Application Ref:	3/2025/0866			 Ribble Valley Borough Council www.ribblevalley.gov.uk					
Date Inspected:	N/A	Site Notice:	N/A						
Officer:	EP								
DELEGATED ITEM FILE REPORT:					REFUSAL

Development Description:	Non-material amendment to planning permission 3/2024/0612 involving increase in roof height, change to external materials, new side access door and introduction of solar panels.		
Site Address/Location:	Land opposite Turner Fold Read BB12 7QZ.

2 Front Elevation
 1 : 50

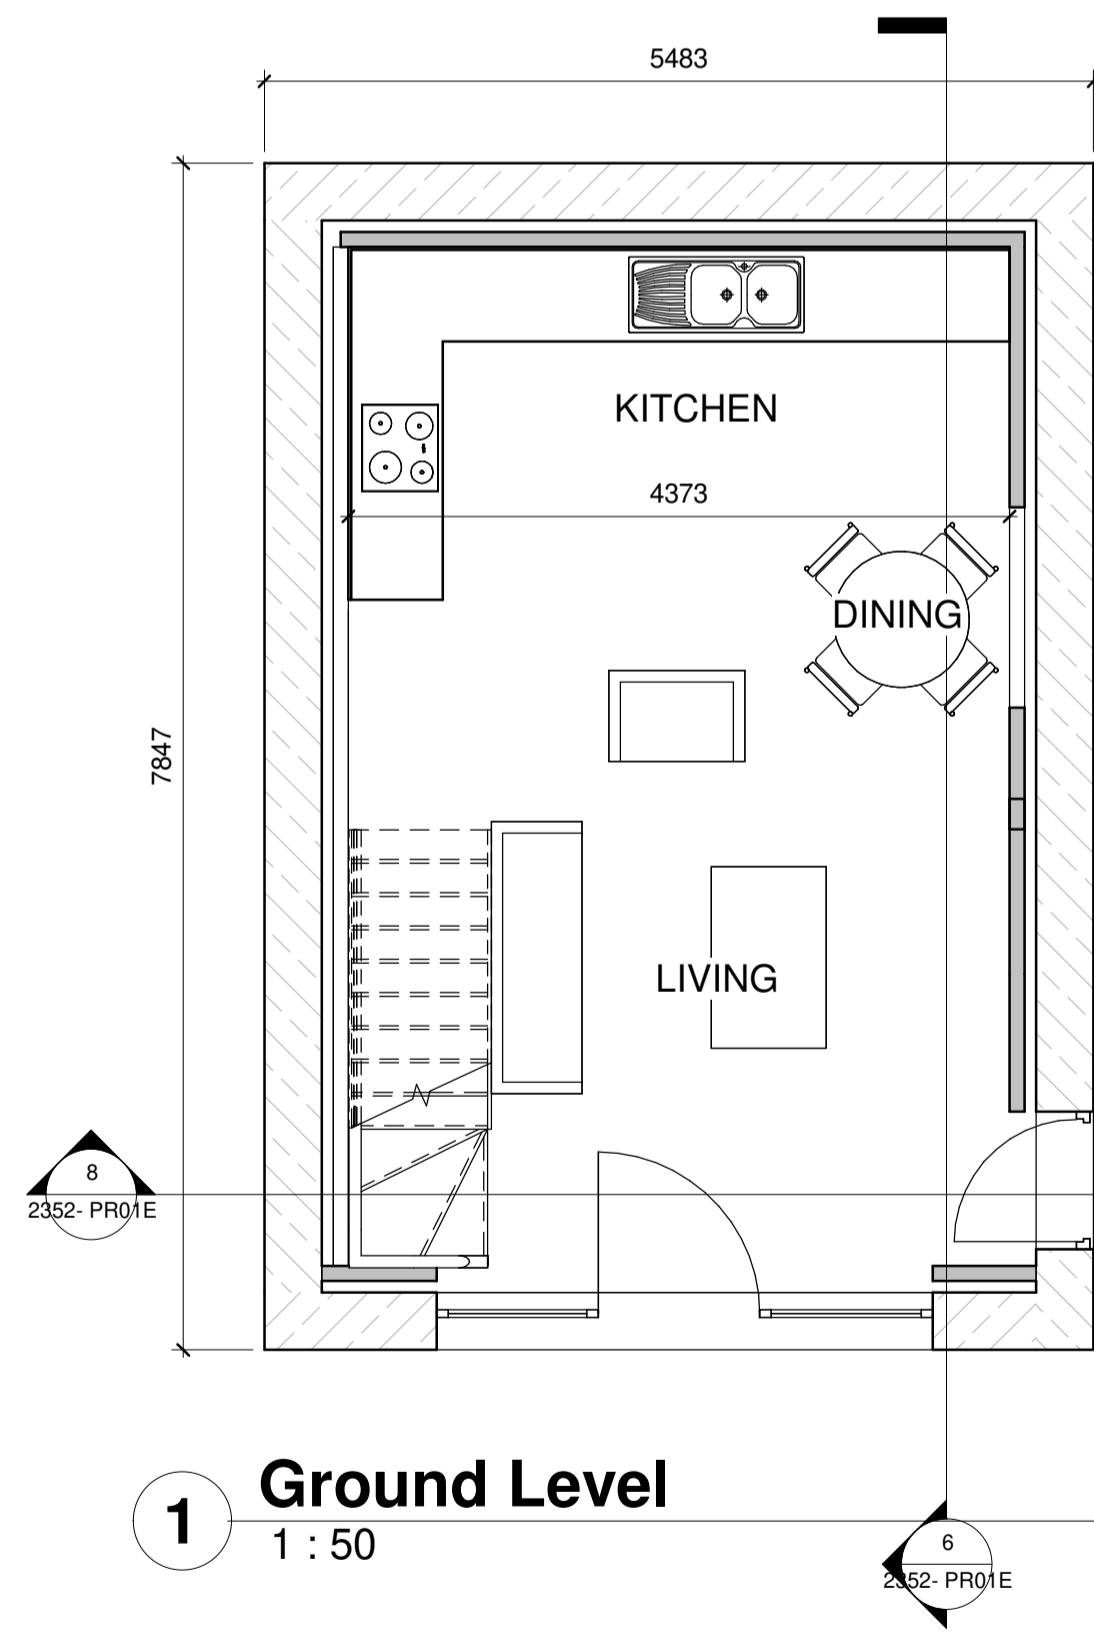
- Introduction of solar panels to the eastern roof slope.
- Principal fenestration alterations including an alternative glazing design to the first floor and the centralisation of the front door.
- The introduction of a reverse gable dormer style roof extension to the eastern roof slope, previously smaller and of flat roof design.
- A change in materials resulting in the entire structure being faced in stone as opposed to partly cladded.
- An increase in the height of the building by approximately 600mm.
- Introduction of a side entrance to the ground floor eastern elevation.

There are a significant number of alterations proposed and given the prominent location of the building all alterations would be highly visible from within the public realm. Accordingly, it is considered that the visual impact of the amendments sought would result in a fundamental change to the design and external appearance of the development originally approved, with the amendments proposed resulting in a development that would be materially different in terms of design and external appearance to that of the original consent.
